## Planning Application 2021/1089

Land to the South East of Higham Common Road, Barnsley (Application 2).

**Hybrid application for employment development comprising:- a) Full planning permission for: earthworks to create development platforms; strategic drainage ponds and associated drainage infrastructure; and location of strategic landscaping and ecological areas. b) Outline planning permission seeking approval over means of access and landscaping for employment use development (use classes E/B2/B8) and associated infrastructure works.**

Figure 3 – Illustrative Masterplan

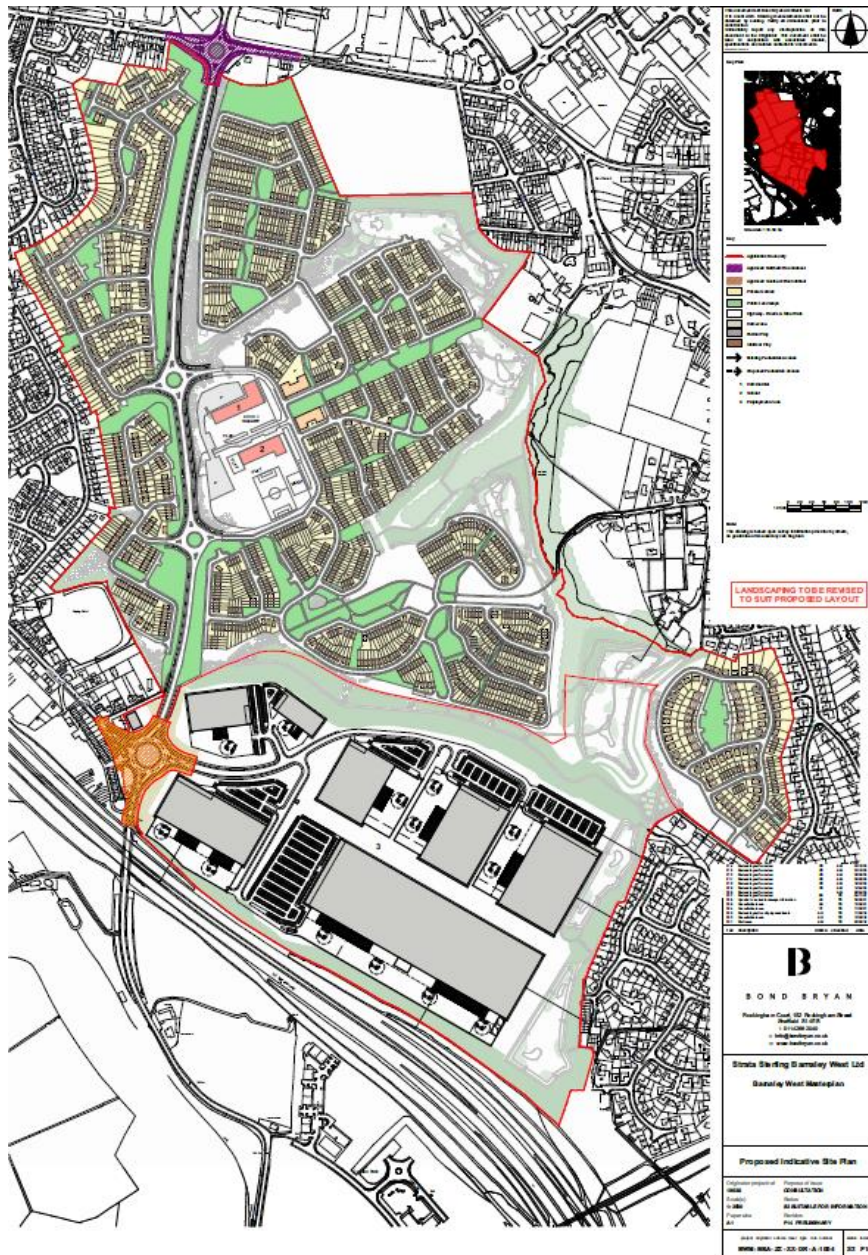
The proposals also include the provision of a new school, sited it would appear from the illustrative Masterplan, next to the proposed link road with all of its additional residential traffic, HGVs and induced traffic flows and all of the problems and pollution that this will bring.

The site layout plan only shows a southern and northern entrance to the main area of Site MU1 using the proposed Claycliffe Link Road. In addition to the additional traffic emanating from the site, there will be additional induced traffic using the Link Road to other areas in the north and south of Barnsley, including HGVs from Claycliffe Business Park and beyond.

As expected, it is noted that the "sheds" shown on the site plan layout will be marketed as suitable for warehouse, distribution and logistics type uses.
